From: Thomas Callaway
Sent: 26 May 2015 09:59
To: Planning.Responses
Subject: RE: Planning Consultation on: M/42/15/HH

APPLICATION NO: M/42/15/HH

Site Address: 37 Lane End Road Ancton Middleton-on-Sea PO22 6LT

Description of Works: Side & rear single storey extension (resubmission following M/10/15/HH).

PROPOSED ROOF PLAN 1/100

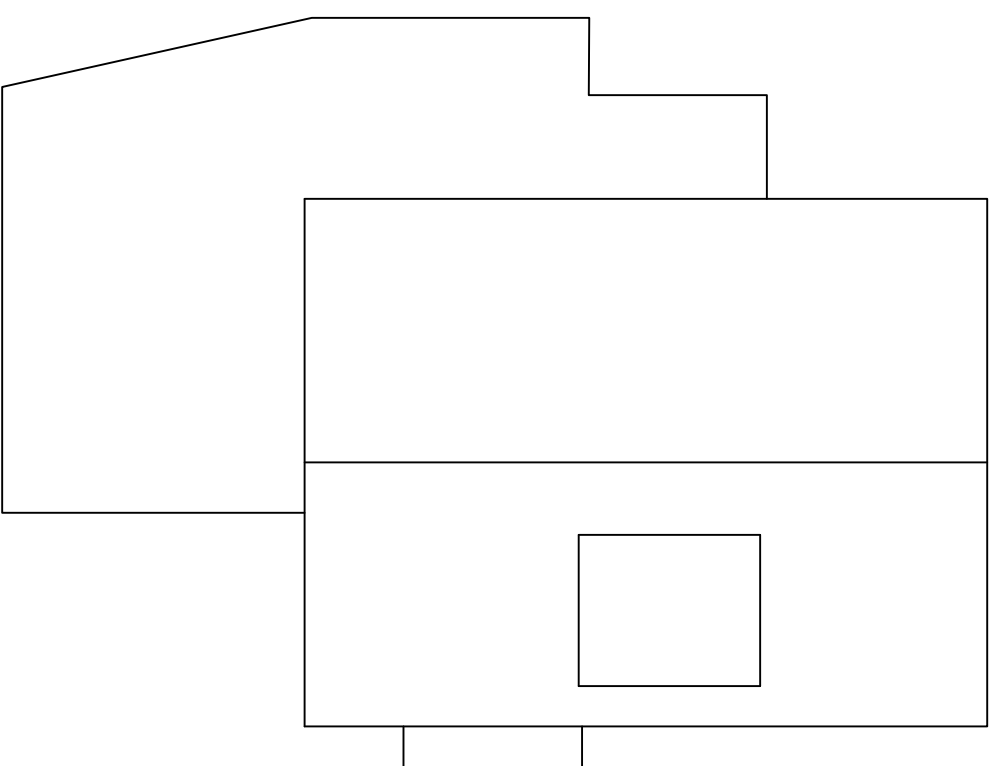
Infiltration must be considered for surface water from all new roof area.
